**WELWYN HATFIELD BOROUGH COUNCIL
EXECUTIVE DIRECTOR - PLANNING, PUBLIC PROTECTION AND GOVERNANCE**

Application No: 6/2017/2062/HOUSE
Location: 11 Fore Street Hatfield AL9 5AN
Proposal: Enlargement of current rear window, installation of rear bi-fold doors and replacement doors and windows to right hand side elevation
Officer: Ms L Sahlke

Recommendation: Refused

PROP. REAR ELEVATION (Recess)

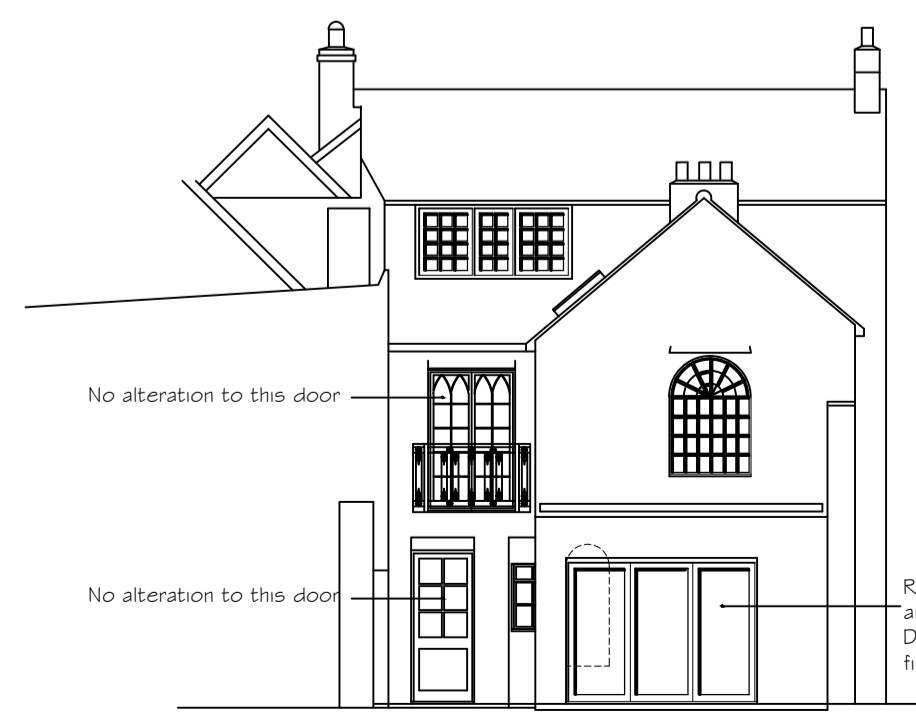
The proposed alterations to the rear elevation of the listed building comprise the removal of the existing arched window and French doors to the ground floor level and their replacement with timber bi-fold doors. It is considered that this alteration would erode the legibility and balance of the fenestration pattern to the rear elevation, which would dilute the buildings architectural interest. In addition, the proposed bi-fold doors would not be in keeping with the character of the listed building. It is therefore considered that the proposed works would cause harm to the significance of the listed building.

1. The proposed development would materially harm the special character of the Listed Building. The removal of the existing arched window and French doors to the ground floor level and their replacement with timber bi-fold doors would erode the legibility and balance of the fenestration pattern to the rear elevation, which would dilute the buildings architectural interest. In addition, the proposed bi-fold doors would not in keeping with the character of the listed building.

PROP. RIGHT HAND SIDE ELEVATION (Part)

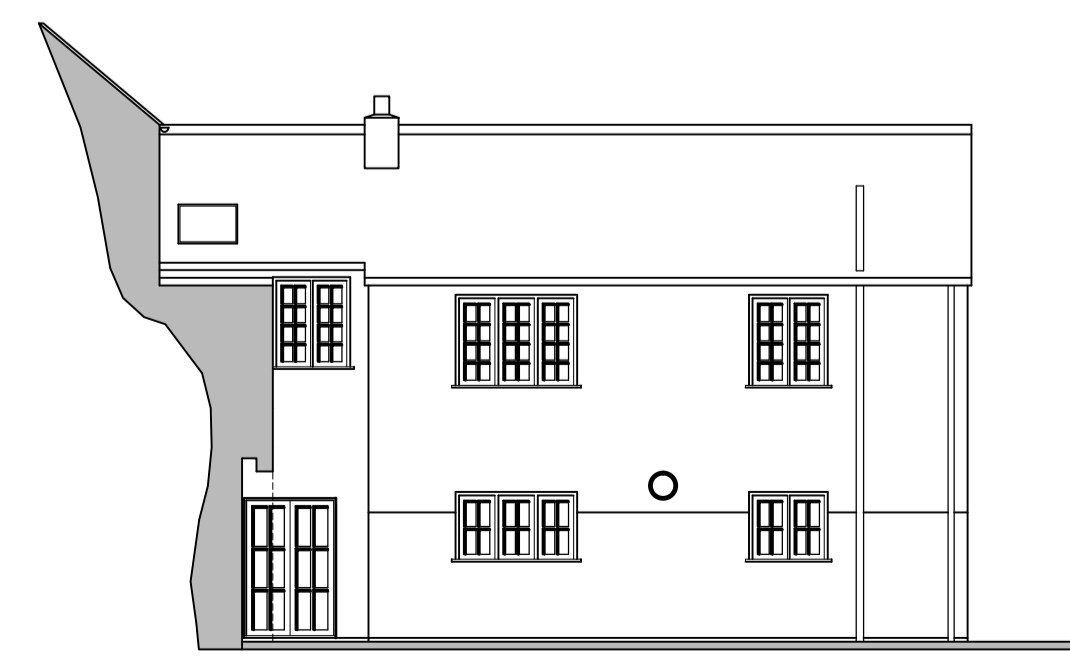
It is also proposed to replace the existing window to the second floor of the rear elevation and the existing windows and door to the west elevation of the rear projection with timber double glazed windows. There is no objection in principle to the replacement of the existing windows and door, however, it is considered that the design and detailing of the proposed windows would considerably alter the appearance of these elevations due to the change to the glazing bars.

Furthermore, the design and detailing of the proposed replacement windows would considerably alter the appearance of the relevant elevations due to the change to the glazing bars, and therefore are considered out of keeping with the character of the listed building.
